Re: Drainage report for a portion of SU land bounded by Phoenix Ave.
and Georgine Drive, N.E.

H-221012 DECEMBER 26, 1979

C-2  
 OF 7

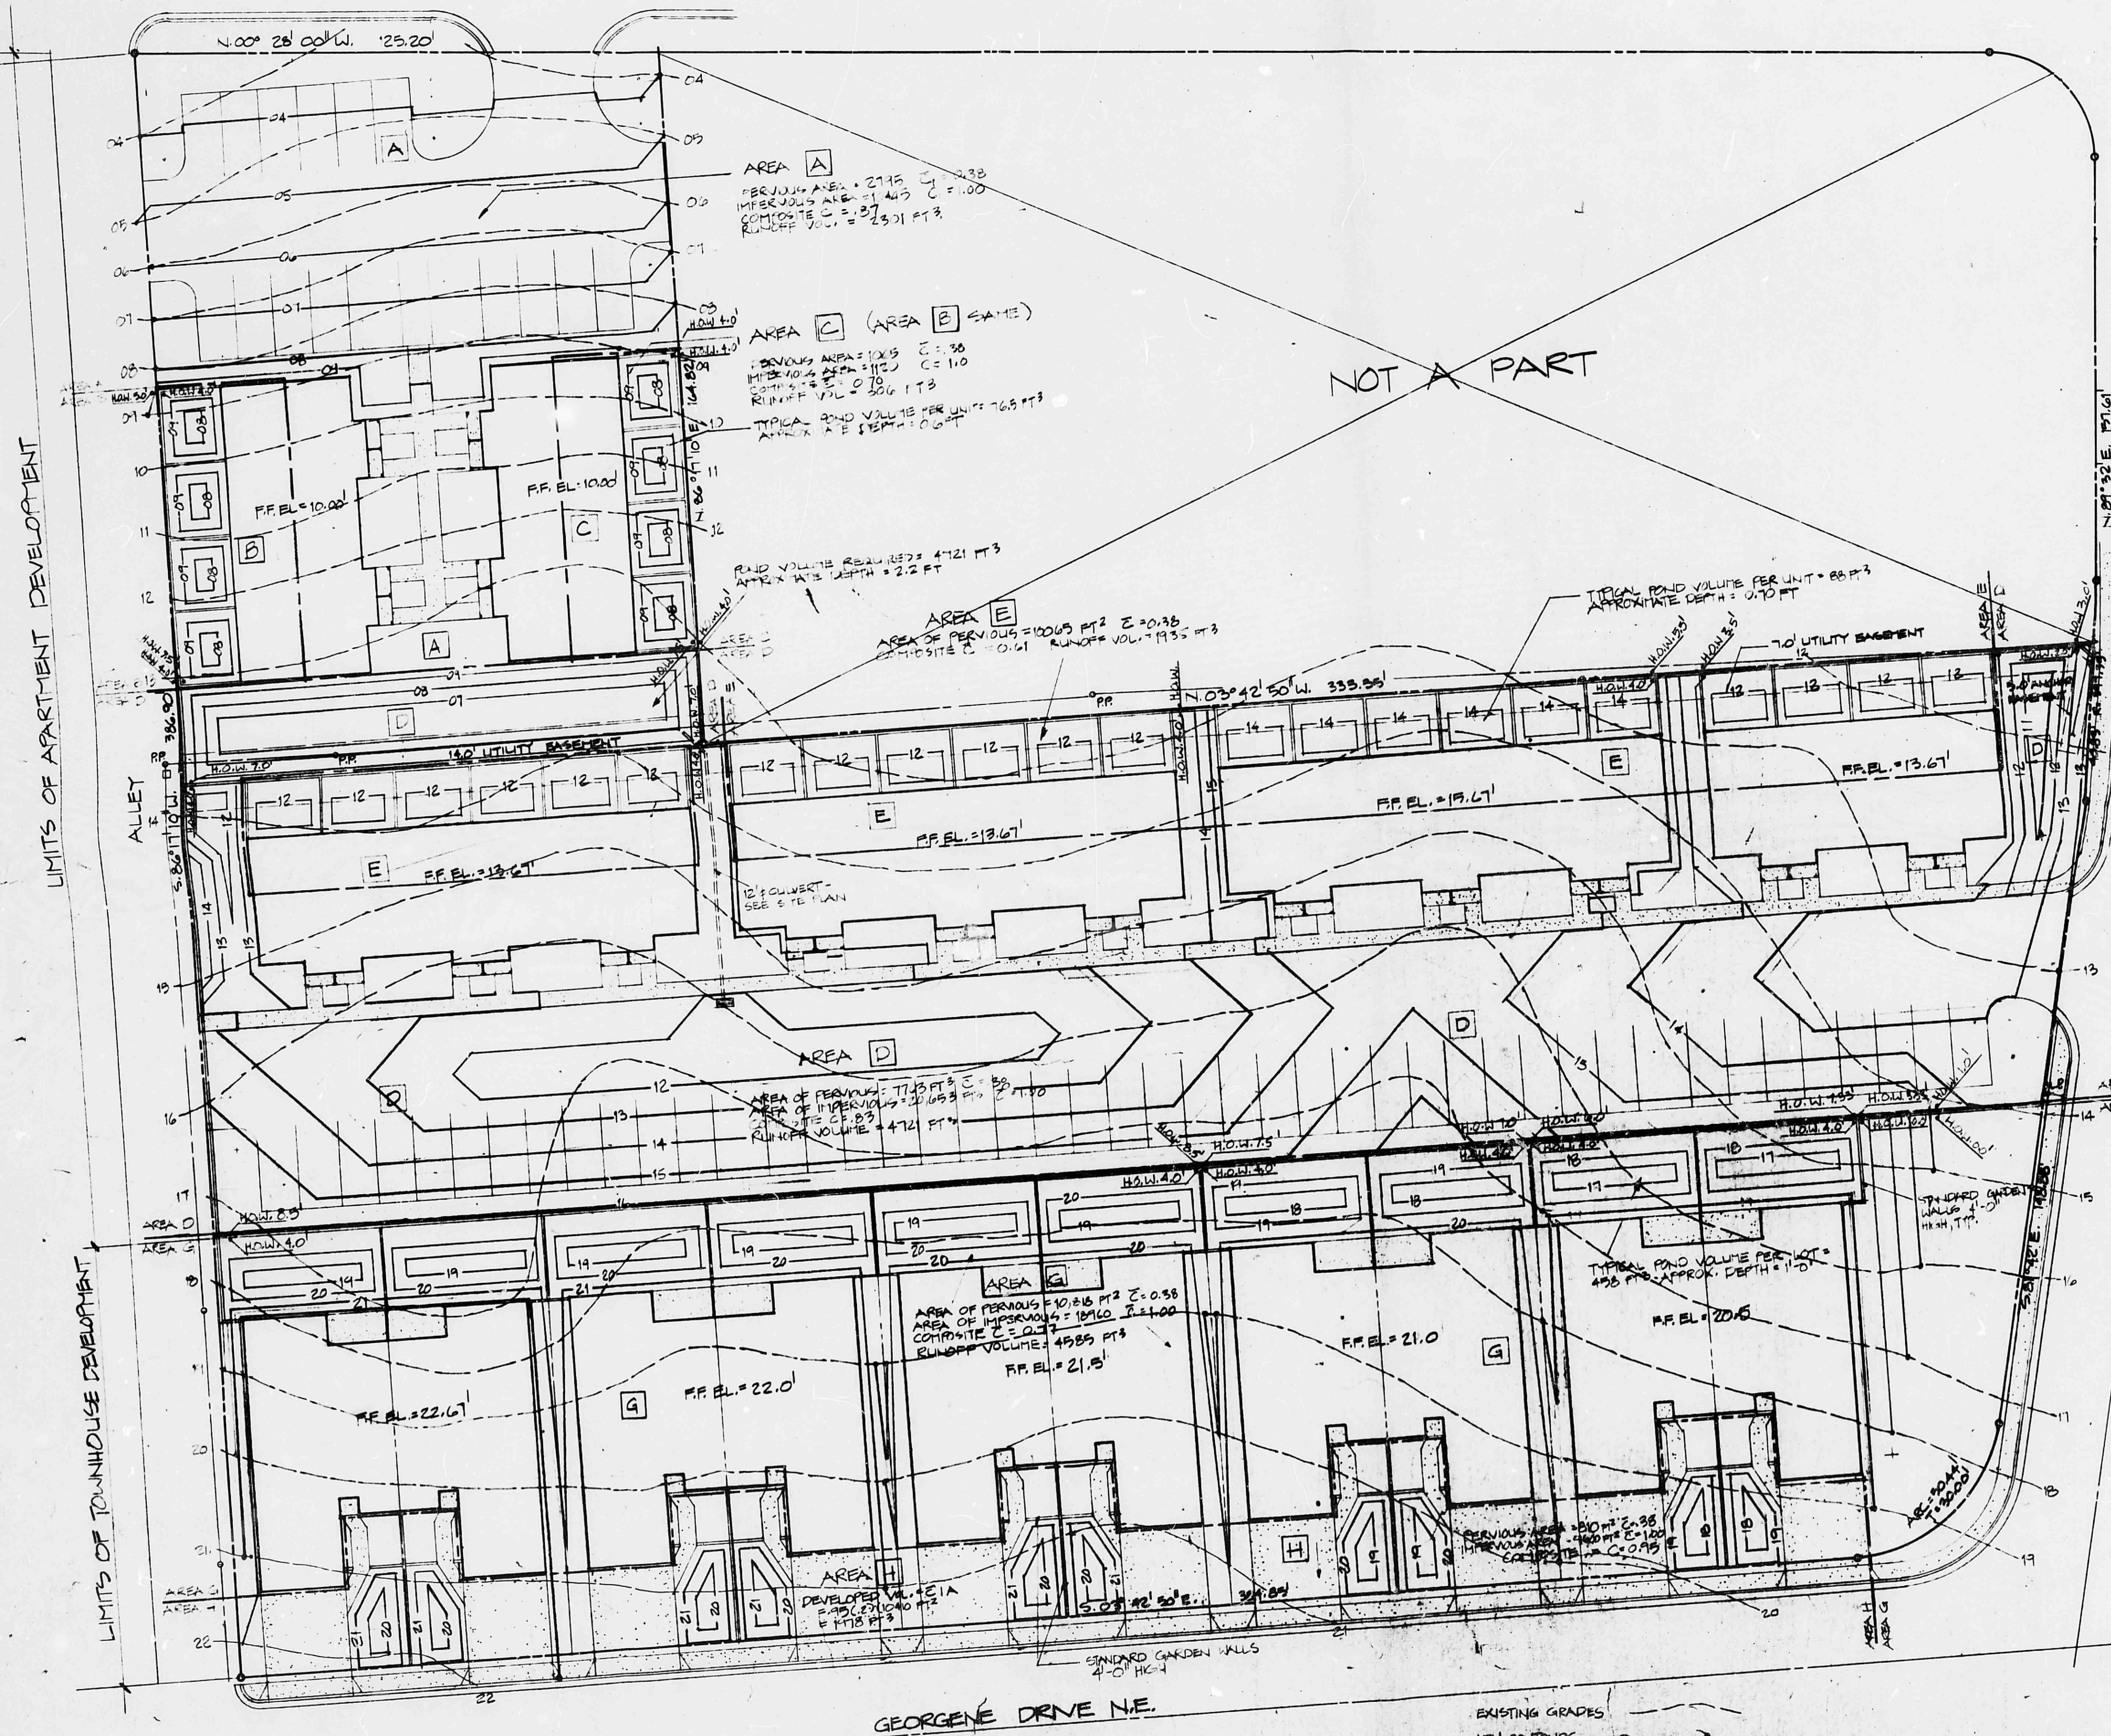
Attached to this note is a sheet of finished contours developed in regard to a drainage report prepared by Rich Gonzalez of MSM. We have had the drainage report in your office awaiting approval for nearly three weeks now.

AMENDED CHANGES "AS-BUILT" TO RUPLEY & ASSOCIATES
DOCUMENT DECEMBER 19, 1979, AND AS NOTED BY
FRED J. AGUIRRE (ASST. HYDROLOGY ENG.) MADE DEC.
24, 1979. DURING THIS MEETING WITH MR. AGUIRRE,
A REPRESENTATIVE OF CREST CONSTRUCTION (CONTRACTOR) & MYSELF,
IT WAS DETERMINED THAT ALL WOULD BE ACCEPTABLE IF
A BALANCE COULD BE SHOWN IN AREA "D" (PARTICULARLY LARGE
POND ON WEST). IF MR. AGUIRRE'S FIGURES ARE ASSUMED
CORRECT: THEN THE LARGE POND MUST CONTAIN

THEY DON'T BALANCE!

3,575 CUBIC FEET. ATTACHED DOCUMENTATION,
VERIFIED IN FIELD BY ME AND ALL GRADE ELEV.
SHOT BY ME BEAR OUT THE FACT THAT

THE POND HAS AT LEAST A CAPACITY OF
3,909.38 CUBIC FEET WHICH IS IN EXCESS
OF THE 3,573 THERE FOR OK. POND ON

SOUTH WAS INCREASED WHILE AT SITE & WILL
POND A MIN. OF 280 FT³ & WILL USE 272 FT³
TO MAINTAIN COMPUTATIONS. NORTH "D" AREA

WILL POND 944 FT³ HOWEVER CITY FIGURE OF
775 FT³ SHALL BE ASSUMED THIS WILL
DEPOSIT 169 FT³ ADDITIONAL TO STREET —

IT SHOULD & MUST BE NOTED THAT THIS
LAND IS ALLOWED 8,641 FT³ OF WHICH

202 — THERE IS ONLY 5,427 FT³ DISCHARGED
TO STREET. NOTE THIS SITE EXCEEDS CITY
OF ALBUQUERQUE STANDARDS & I HEREBY
VERIFY ALL DATA TO BE CORRECT. THIS
MEANS THIS SITE CONTAINS 3,114 FT³ MORE
THAN REQUIRED.

3,685 > 2436.3 ∴ NO RUN OFF TO STREET.

5061.24 < 8541 ∴ STILL BELOW HISTORICAL
& THEREFORE OK.
